Planning Department
Alan Varela, Interim Director

January 13, 2022
Ron Bohannon
Tierra West, LLC
5571 Midway Park Place, NE
Albuquerque, NM 87109

Re: The Wymont- 8220 Montgomery Blvd NE
ESC Plan Engineers Stamp Date: 1/6/2022 – G19E004A

RONALD R. BOHANNAN P.E. #7868	THE WYMONT ALBUQUERQUE, NM EROSION CONTROL PLAN	DRAWN BY pm
		DATE 11-23-21
 11-23-21 RONALD R. BOHANNAN P.E. #7868	 TIERRA WEST, LLC 5571 MIDWAY PARK PL NE ALBUQUERQUE, NEW MEXICO 87109 (505) 858-3100 www.tierrawestllc.com	DRAWING
		SHEET # SW-1
		JOB # 2021008

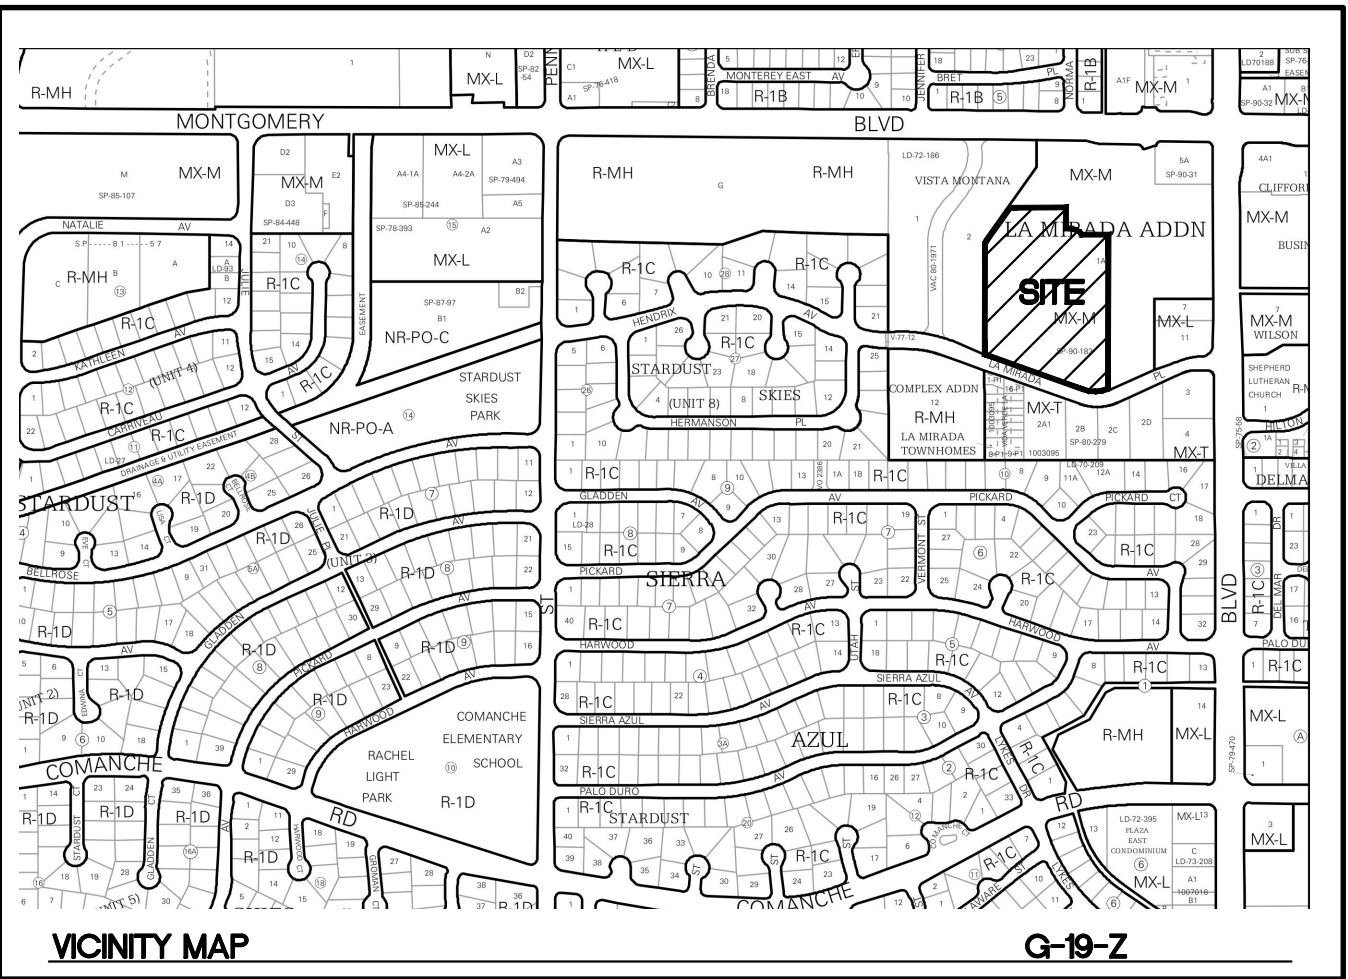
1. The ESC Plan can't be approved until after Hydrology approves the G&D Plan(s). The proposed grading must be shown on the ESC Plan and it must agree with the approved G&D Plan. Proposed contours are missing.
2. Show only the streets and common access drive aisles and sidewalks to be constructed with this subdivision. Remove the commercial buildings and parking lots and the residential driveways and sidewalks that won't be built with Wymont LLC's Work Order.
3. The Land and Infrastructure" inspection and review fee, \$605.00, has already been paid. Separate operators will pay fees for Esc Plans when Building Permits are pulled for the lots. A \$75 resubmittal fee will be charged each time this ESC Plan is resubmitted.
4. Update the engineer's stamp date each time the plan is changed (all 4 sheets).
5. Also be advised that the 2017 CGP expires in one month to be replaced by the 2022 CGP.
